From: Eve Hearsey
Sent: 09 March 2012 14:17
To: Planning.Responses
Subject: FW: FG/16/12 - Minor Material Amendment - Asda (Country Fayre), Littlehampton Road, Ferring.
Attachments: Compack8 brochure new.pdf; Flexy II PCA 0208.pdf

From: Eve Hearsey
Sent: 01 March 2012 15:33
To: John Green; Graham Evans
Subject: FG/16/12 - Minor Material Amendment - Asda (Country Fayre), Littlehampton Road, Ferring.

Proposed Roof Plan

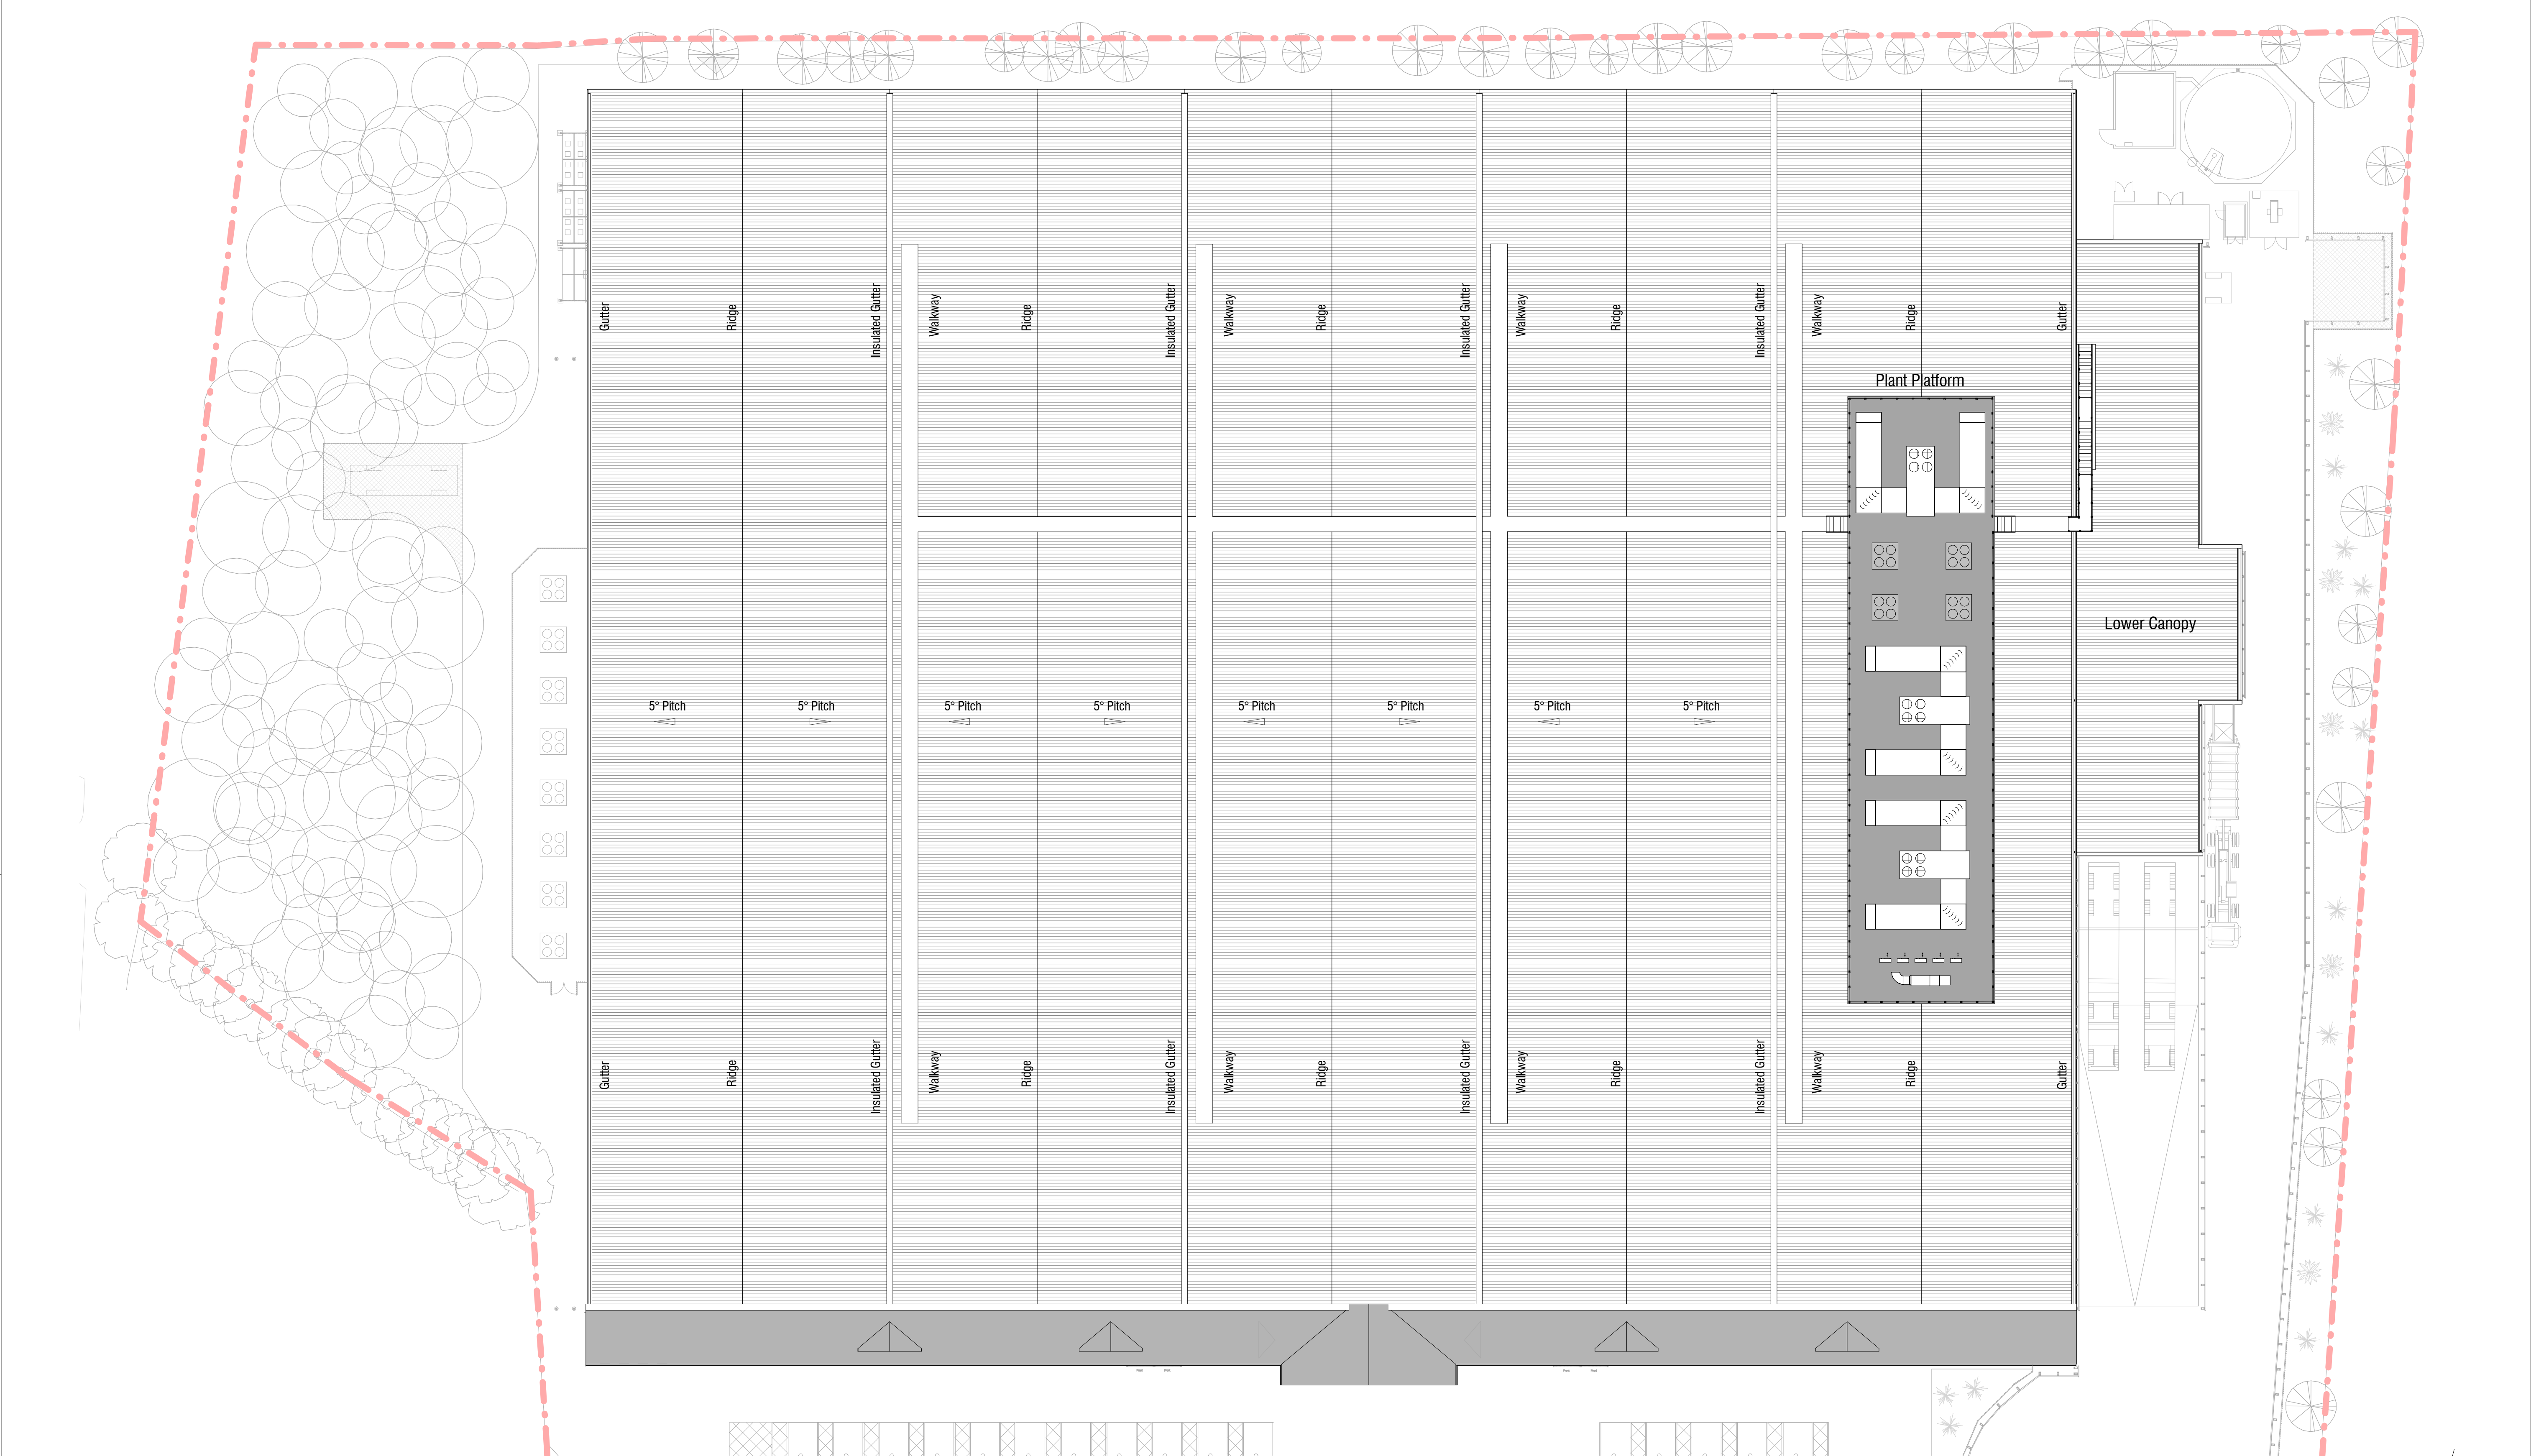
No information is provided in respect of noise produced by the plant, existing background noise levels, or predicted noise levels at nearest sensitive premises, so definitive comment is not possible. It is noted that the scheme does not propose any screening to either plant compound. I did consider the the potential impact of noise from plant and in view of the separation distance to the nearest sensitive residence ("Huntley" @ 100m+) I did not consider that noise from modern, well maintained plant at this distance was likely to be significant. Noise arising on this site may have a greater impact on future sensitive development in closer proximity and may be a consideration in any application for such development.

You have responded to the above thank you, but I have been asked to check that you have considered both the air conditioning units on the roof together with the refrigeration plant on the east side of the supermarket and the pump room etc. on the west side of the building, particularly with regard to the surrounding residential properties.
